**Sent:** 07 October 2013 18:16  
**To:** Planning  
**Subject:** Welwyn Hatfield Council Online Planning - Comment

Application Number: N6/2013/1938/MA

Comment Type: Object

Title Proposed Materials

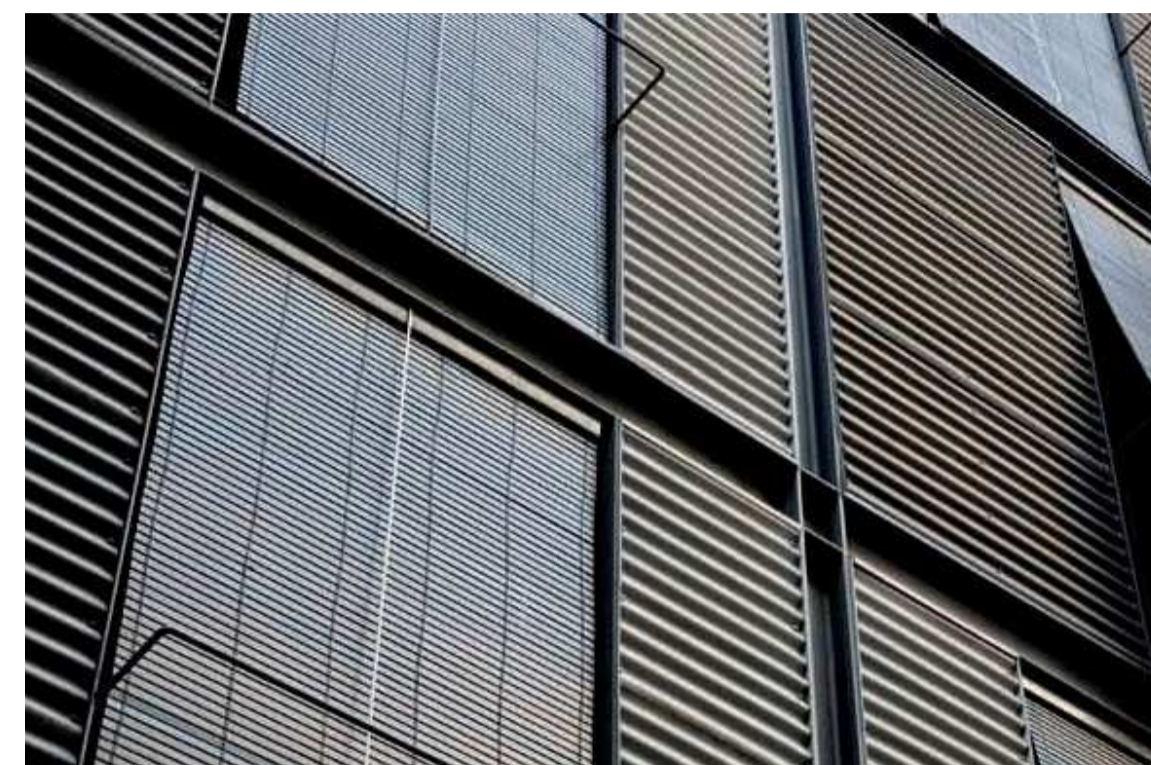
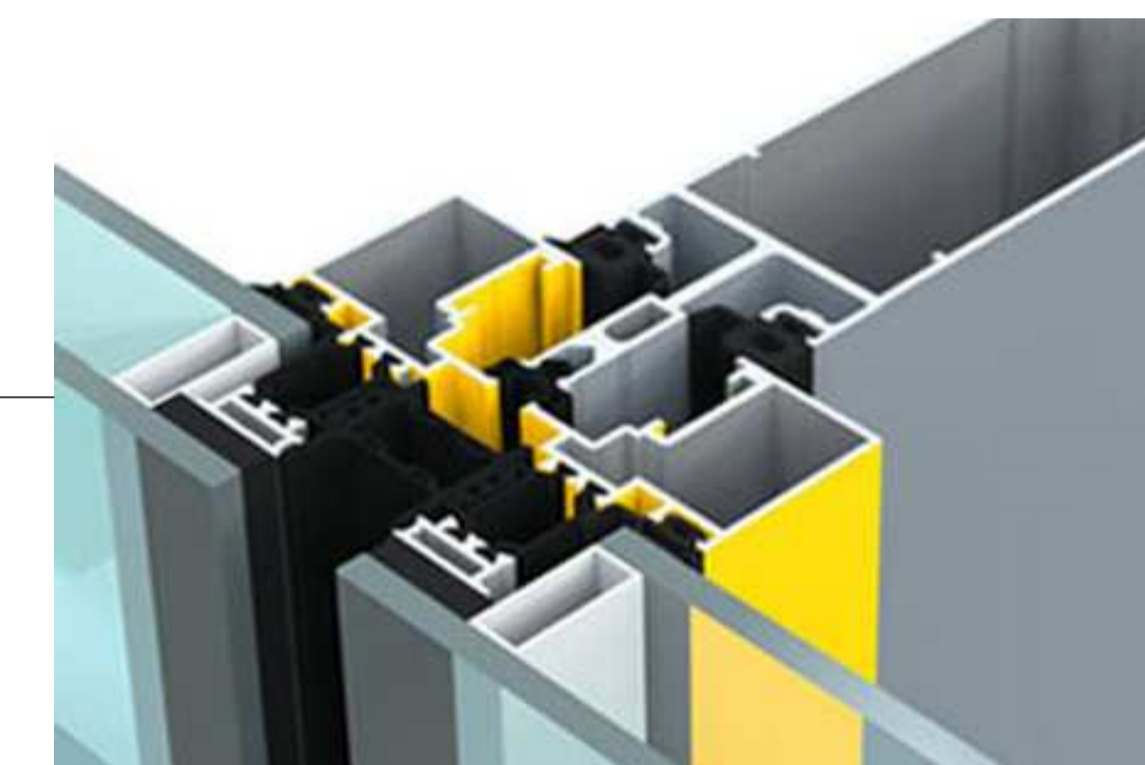
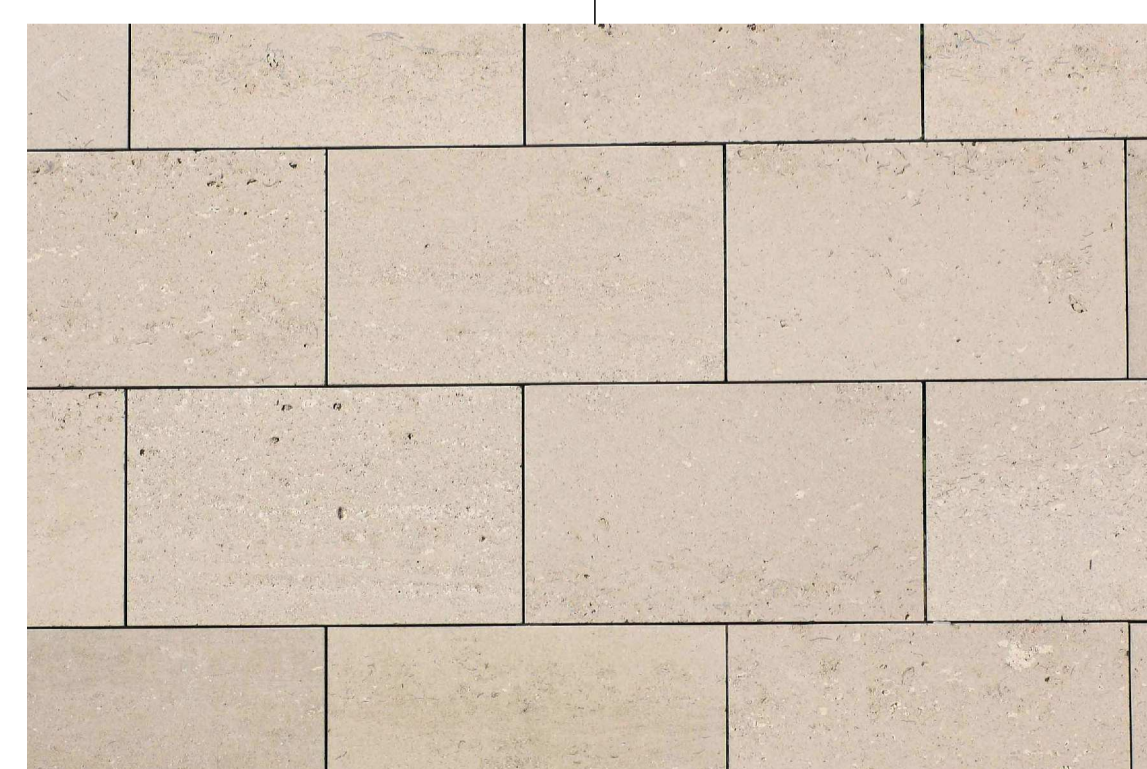
The proposed external design is entirely out of sympathy with the original award-winning building, with no thought for the context, materials, proportions or scale of the original building. It is incongruous and does nothing to improve the current rear elevation, but only makes it worse.
